City of Portland, Maine - Building or Use Permit Application

Location of Construction: 1103 Forest Ave	Owner Name: Shalom House Inc	Owner Address: 400 Congress St	Phone: 207 774 9000
Business Name:	Contractor Name: Thaxter Corporation	Contractor Address: Box 7320 One Canal Plaza Portland	Phone: 207 774 9000
Lessee/Buyer's Name	Phone:	Permit Type: Alterations - Commercial	Zone: B-2
Past Use: Commercial - the Creative Resource Center	Proposed Use: Shalom House / Renovated existing 3 story building to a 6 bedroom handicap family unit	Permit Fee:	Cost of Work: CEO District:
Proposed Project Description: Renovated existing 3 story building to a 6 bedroom handicap family unit		FIRE DEPT: <input checked="" type="checkbox"/> Approved <input type="checkbox"/> Denied	INSPECTION: Use Group: R4 Type: 3.0 2/15/05 signature: <i>[Signature]</i>
		Signature: <i>[Signature]</i>	signature: <i>[Signature]</i>
		Action: <input type="checkbox"/> Approved <input type="checkbox"/> Approved w/Conditions <input type="checkbox"/> Denied

Proposed Use: Shalom House / Renovated existing 3 story building to a 6 bedroom handicap family unit	Proposed Project Description: Renovated existing 3 story building to a

PROJECT: SHALOM HOUSE 1103 FOREST AVE. PORTLAND, ME	DRAWING: POST DETAILS
	ARCHETYPE, P.A. PORTLAND, MAINE
SCALE: As Noted	
DATE: Feb. 23, 2005	SKa - 2

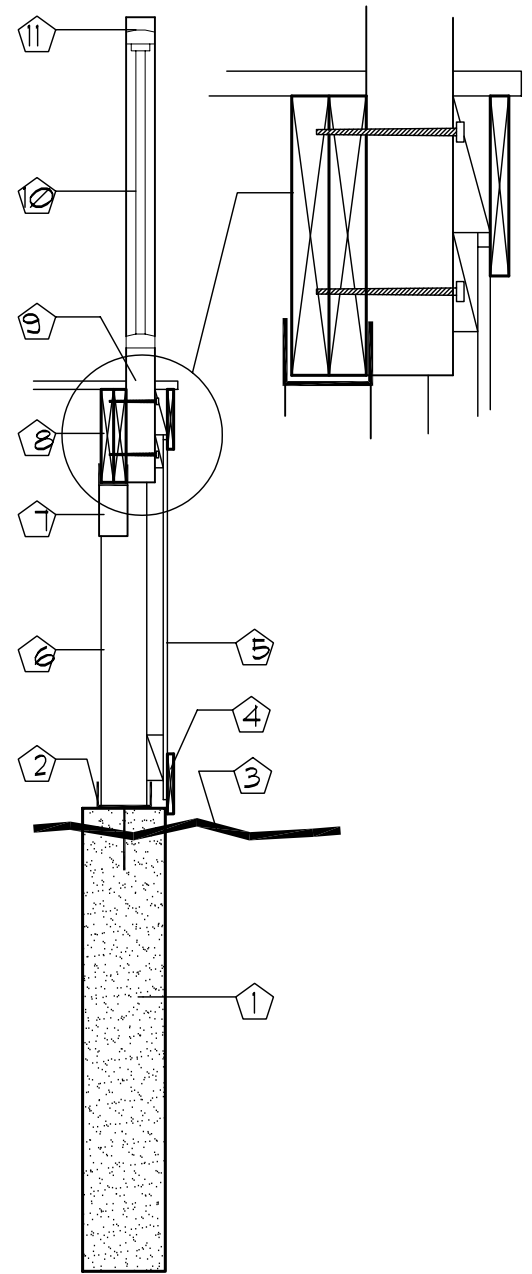
2/17/2005-mjn: Emailed and Spoke w/ John Shields, need structurals on Deck and Ramp. Headroom on third floor is only 6'8" and the use group class should be R4 not R2

1 BUILDING SECTION
SCALE: 1/4" = 1'-0"

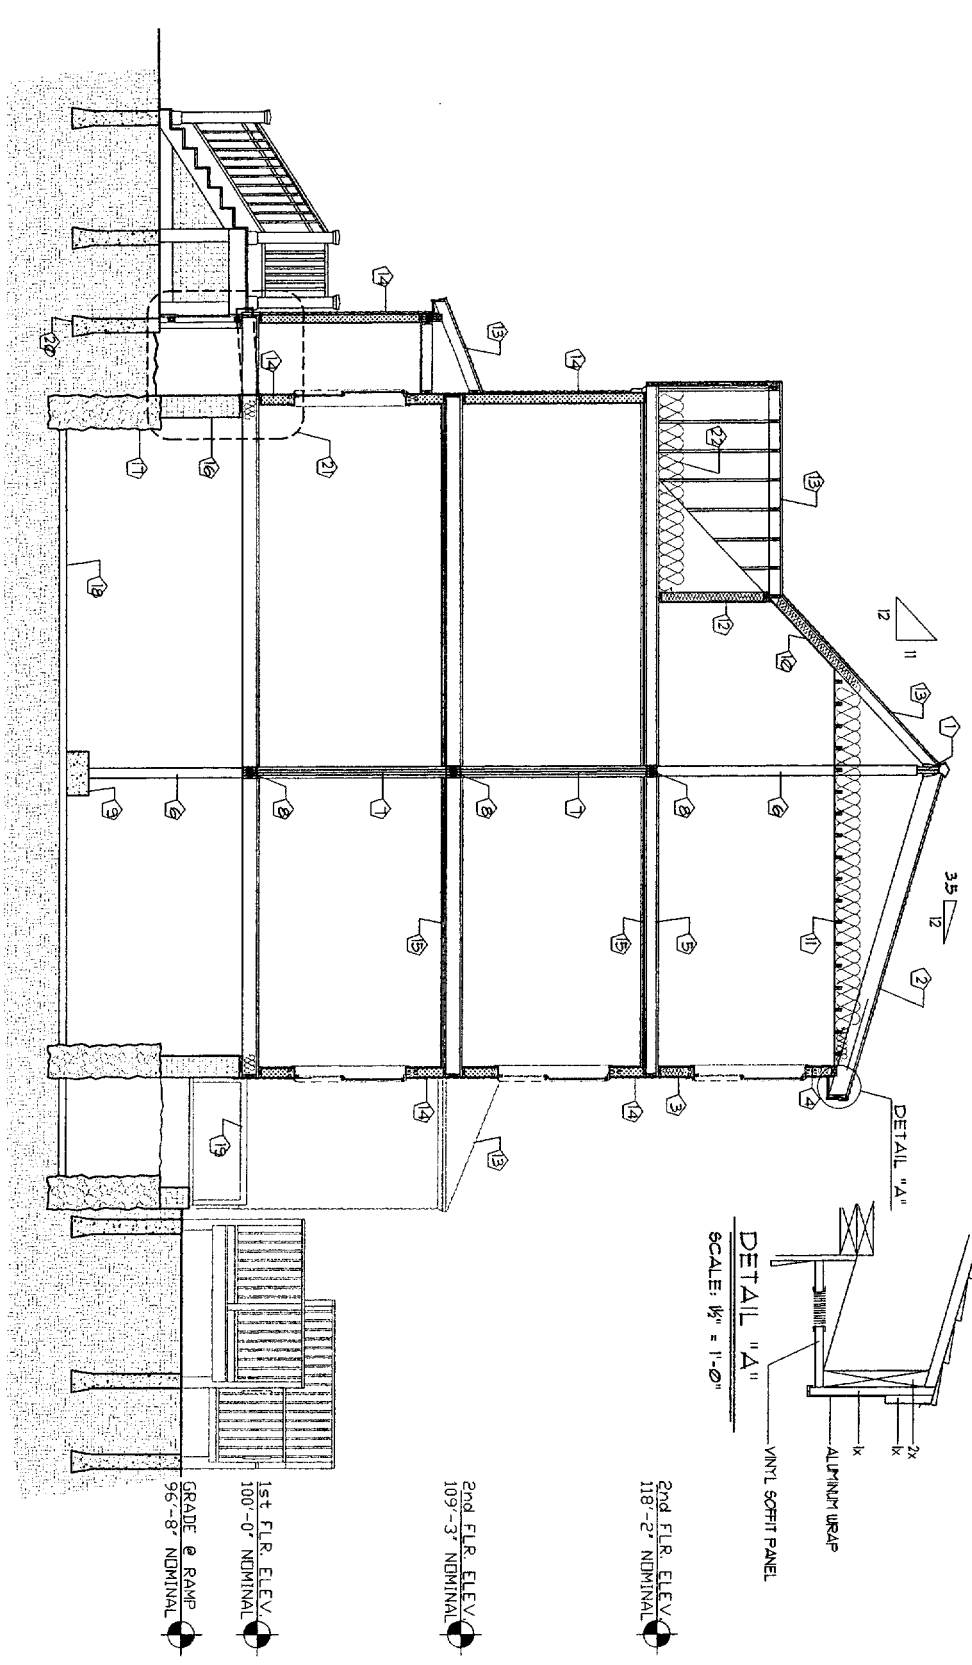
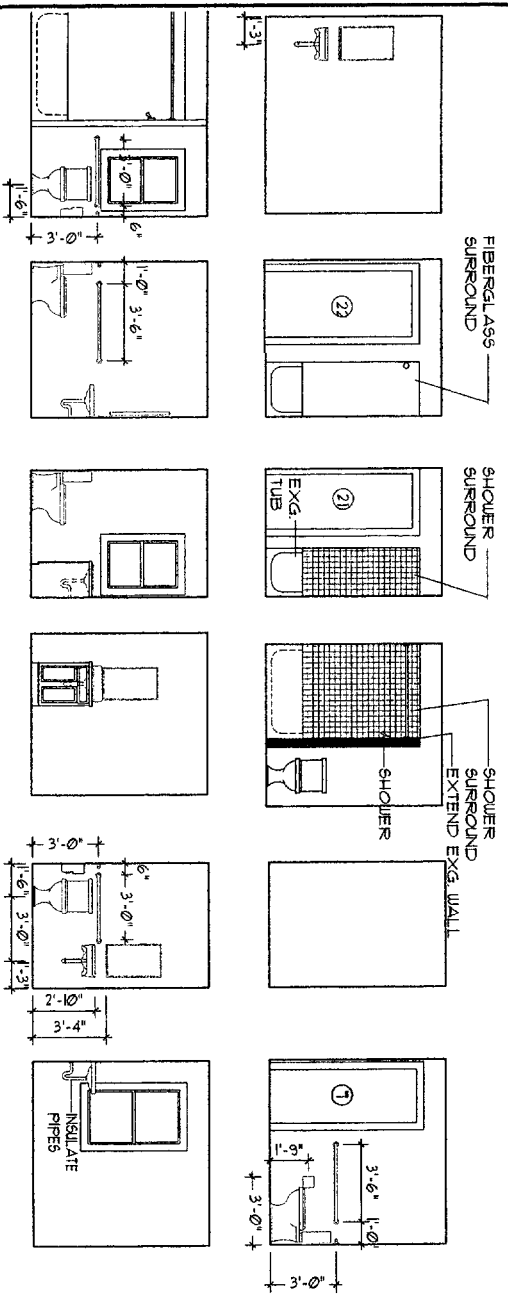
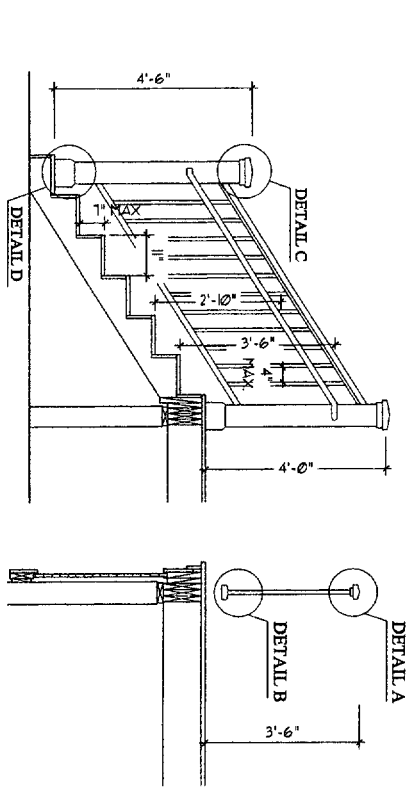
Page A1 of the Shalom House plans shows a ceiling height of 6'8" on the new third level. Section R305.1 requires that it be 7'.

Are the stairs to the third floor new? Either way what are the tread and riser and width and headroom dimensions.

1. Attached is a revised form listing the occupancy as R-4.
2. Attached is Ska-1 with structural details of the ramp/stair system at the rear of the house.
3. Headroom: see Building Section 1/A.4. The ceilings on the third floor are 8'-0" A.F.F. throughout, except in Bedroom 304 where there is a knee wall condition. The knee wall condition reduces the headroom to less than 7'-0" in 26 square feet of the bedroom, the remaining 134 square feet have headroom equal to or greater than 7'-0". This bedroom meets the requirements of Section R304.
4. The stair from the second to the third floor is new and is detailed on Drawings 2a & 2b/A.4. Basically it is 7/11, 36 clear tread width, handrails both sides.
